RE: Response to ExQ2 Q15.0.8

Harwich Haven Authority – Response to ExQ2 Q15.0.8

Harwich Haven Authority (HHA) welcomes the opportunity to provide further clarity on operational conditions and navigational constraints affecting the Sunk Inner and Sunk Outer Precautionary Areas in relation to the proposed North Falls Offshore Wind Farm. As the statutory harbour authority responsible for the safety of navigation in the Harwich Haven area, including key access channels to the Port of Felixstowe and Harwich International Port, we maintain an active role in ensuring maritime safety and operational efficiency.

Deep Water Route Cable Installation Areas (Future Dredging Depths) Plan

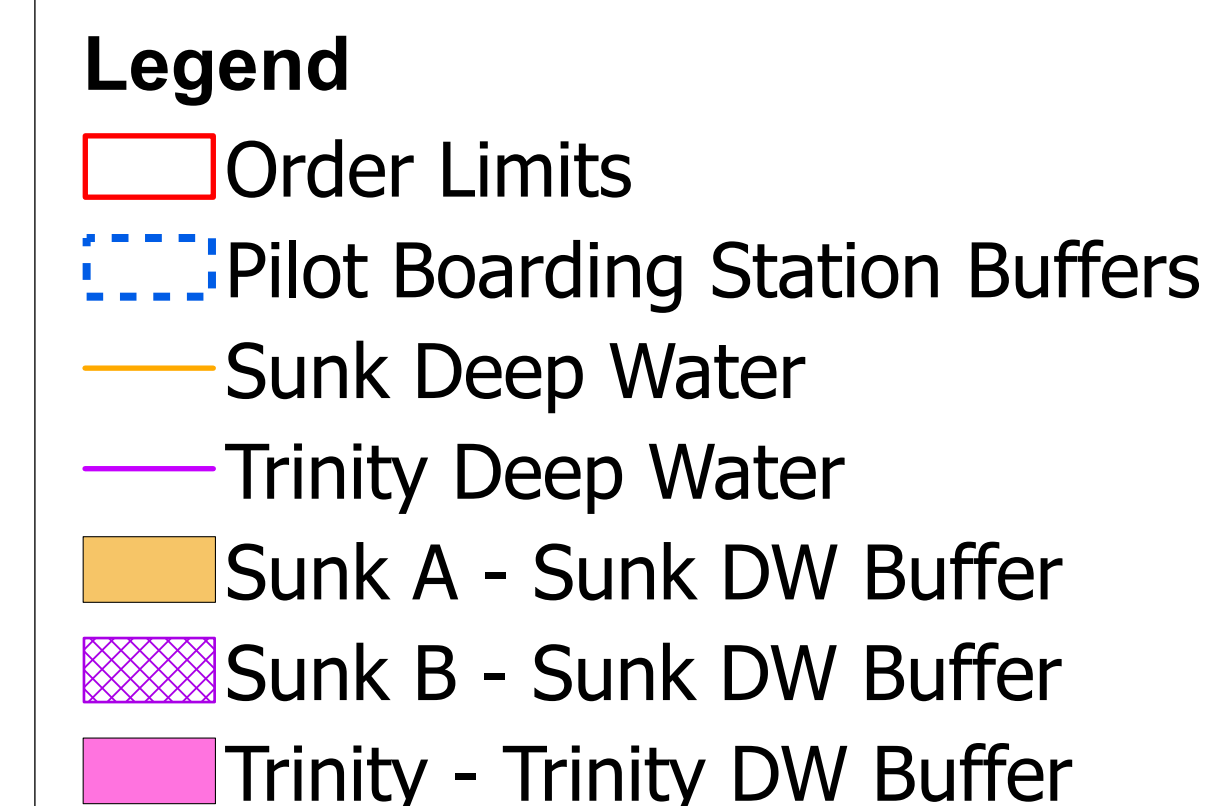
HHA acknowledges the applicant's updates to the Outline Navigation and Installation Plan [REP4-011] and the accompanying Deep Water Route Cable Installation Areas Plan [REP4-043]. However, we believe the control measure need to be contained within the body text of the DCO and embedded marine licence as protective provisions and not just referenced as a required for a plan or document such as an Outline Navigation and Installation Plan.

5. In the Sunk area, cable depth needs to consider that the world's largest vessels may anchor and dredge anchors in emergency scenario.
6. The cable depth must take into account the draught of current and future vessels and future dredging. The DCO should provide for a maximum draught of 20m plus 10% UKC, as such minimum depth required 22m below chart datum.
